Your Ref:
Our Ref: LU/63/11/
Please ask for:
Mr N Crowther

16th August 2011

Outline Application for the construction of the "Fitzalan Link Road" between the A259 Worthing Road & the East Street/Fitzalan Road roundabout - This application affects a Public Right of Way
Fitzalan Link Road Littlehampton

Thank you for your internet comments made on 16th August 2011 and recorded as follows:

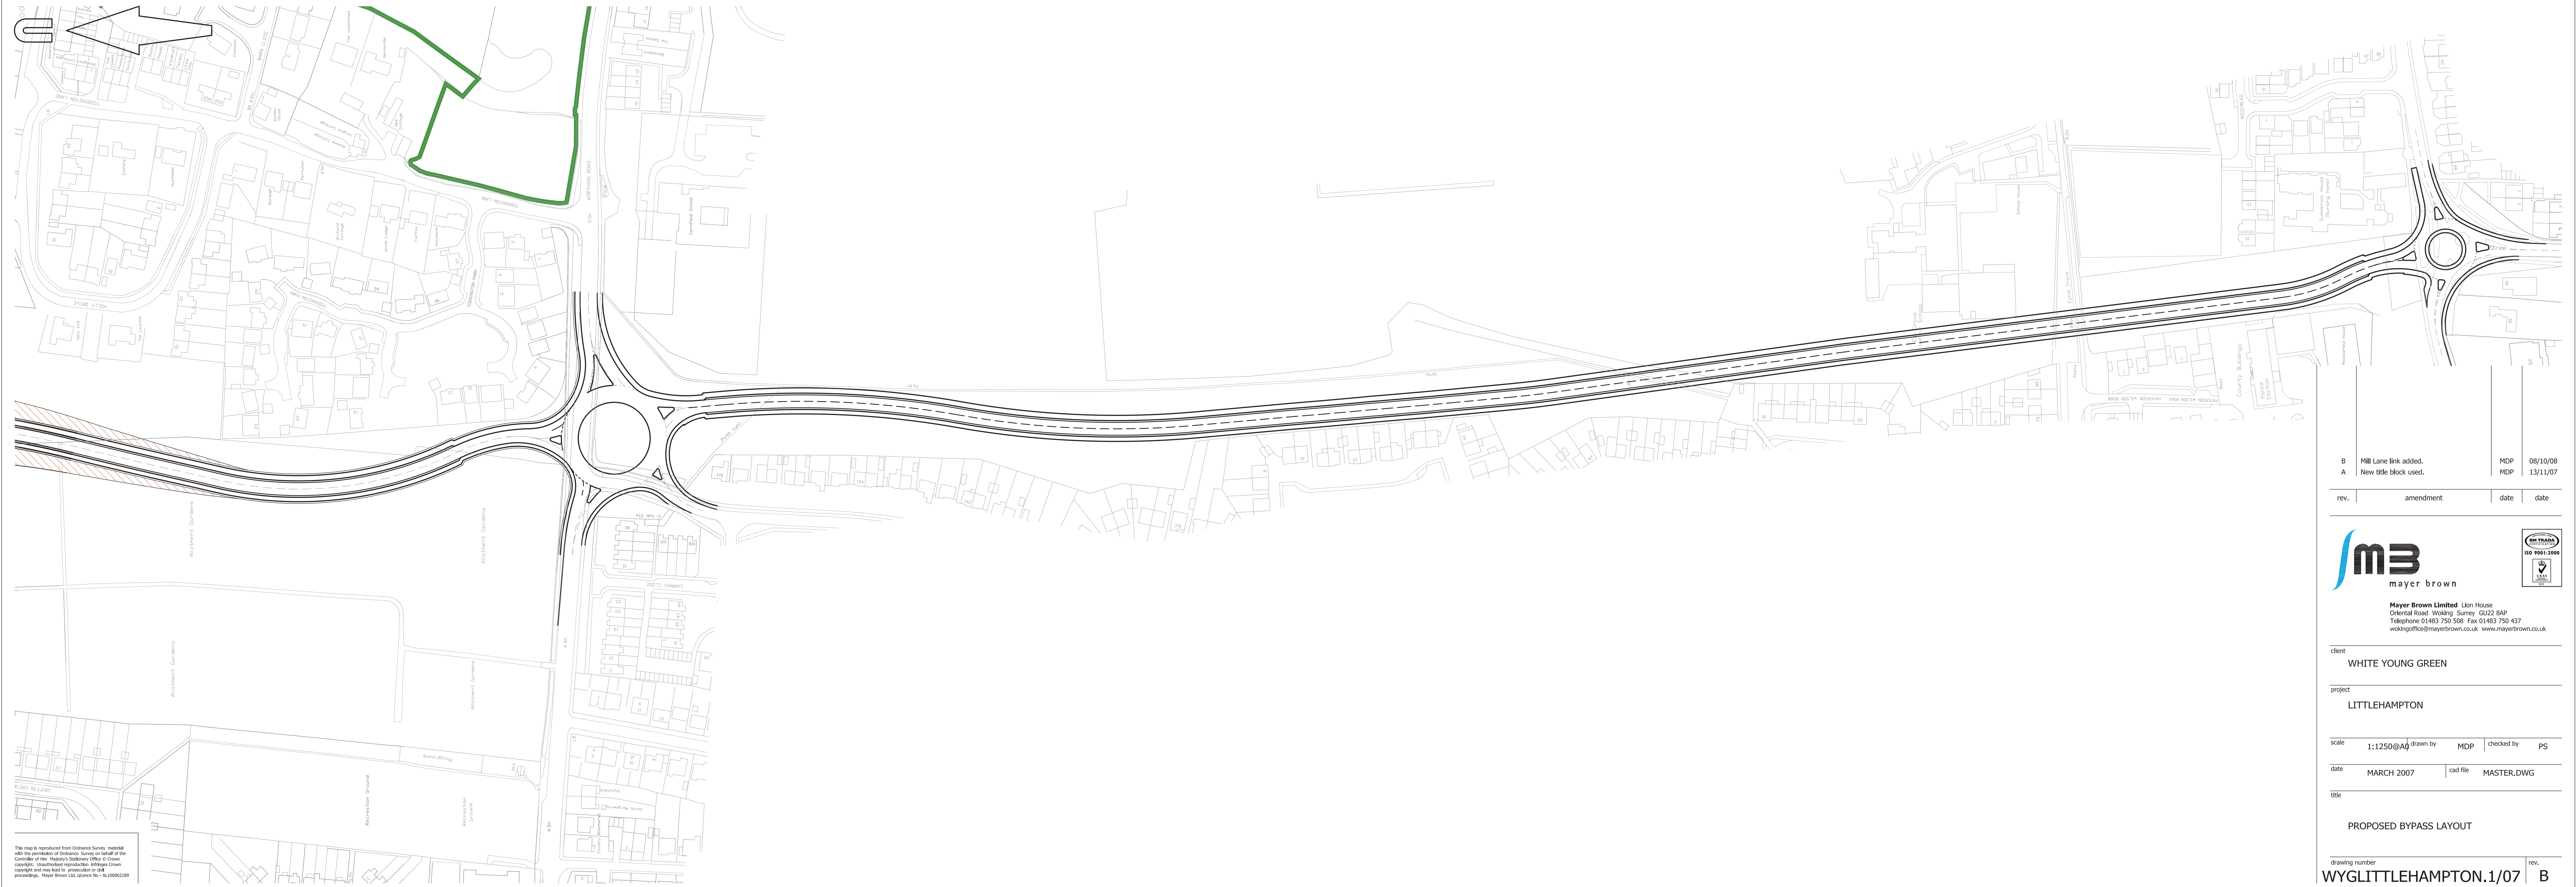
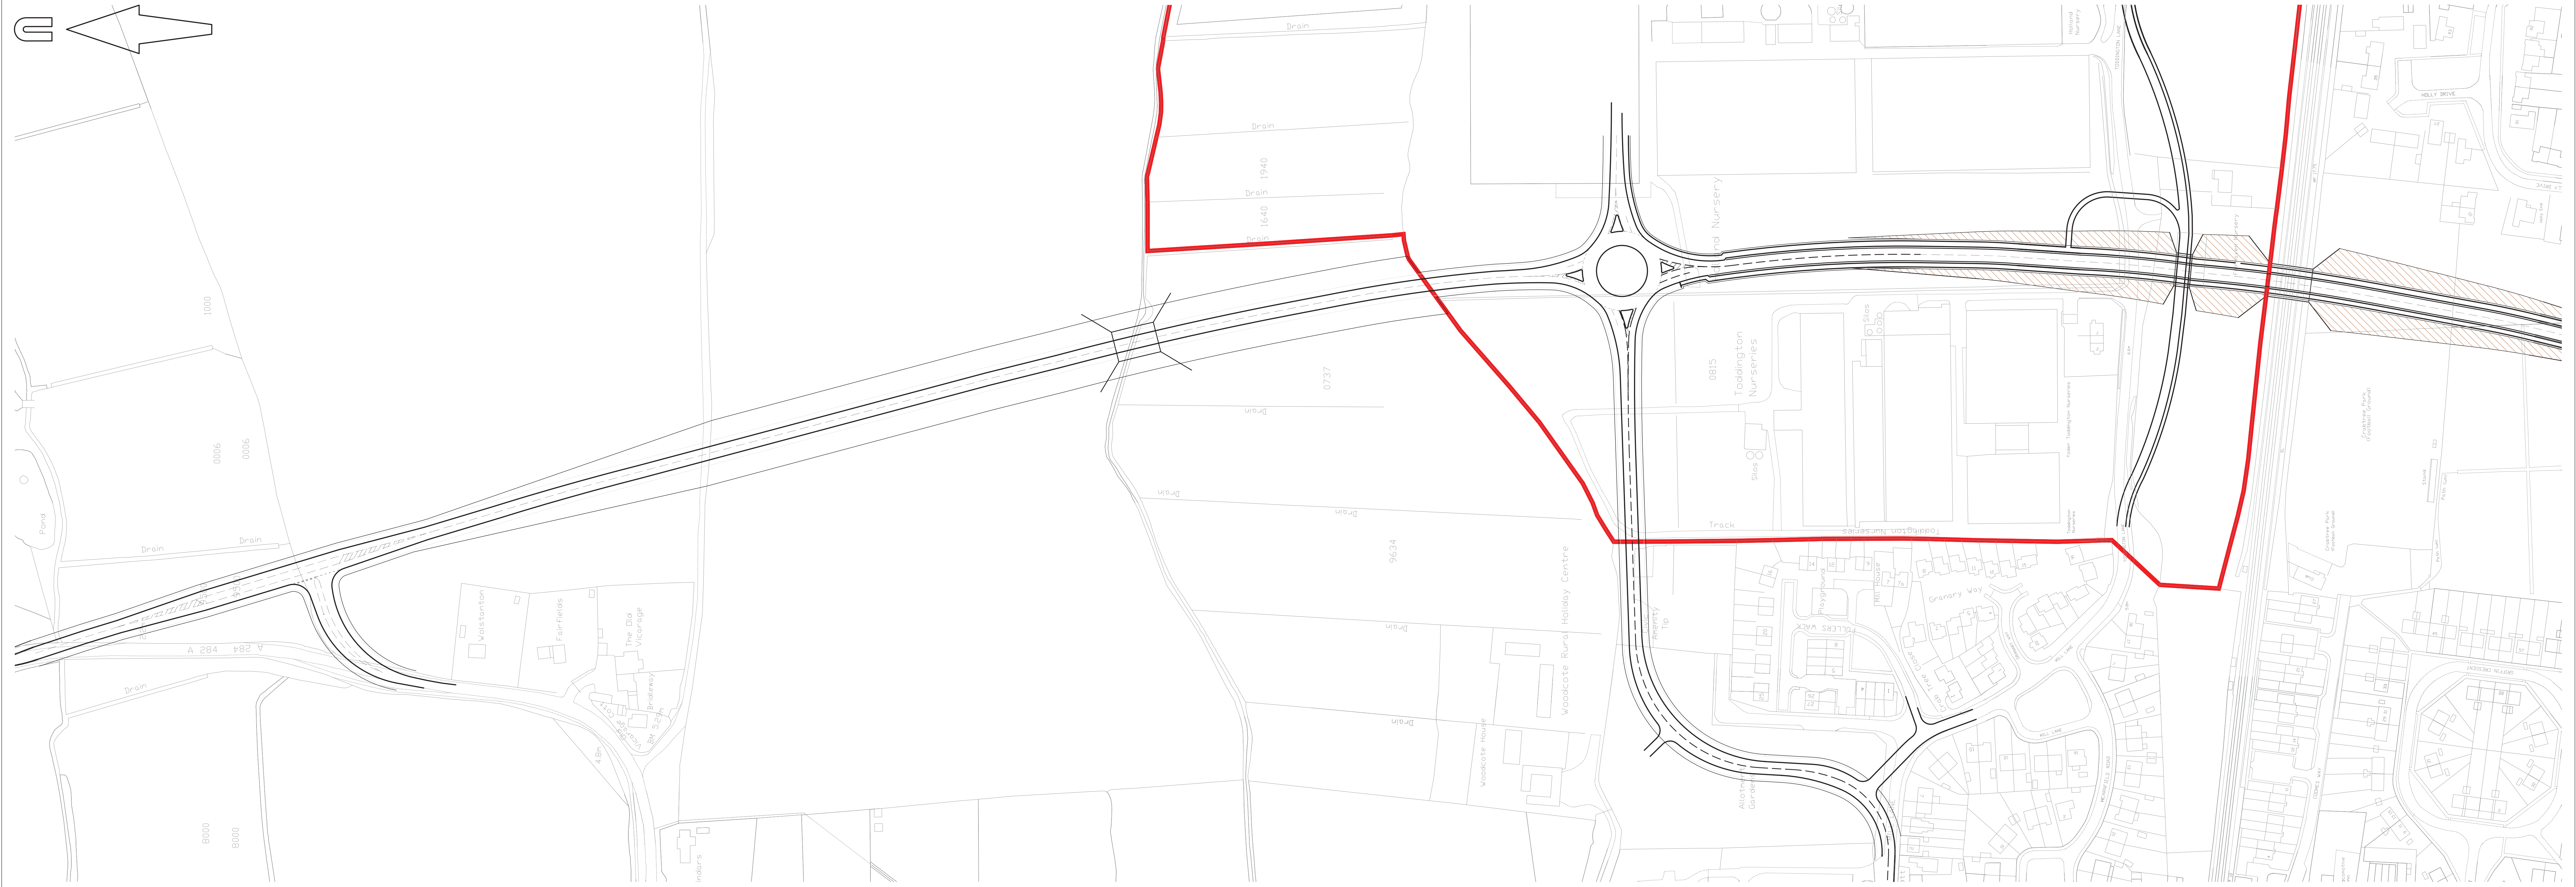
*The Town Council raised no objection to this application but would like to make the following comments:
Road width insufficient.
Would like to see double yellow lines and no parking on both sides.
Bus layby - suggest the stop on the west side is opposite the one on the east side.
Are the crossing facilities for the road adequate?*
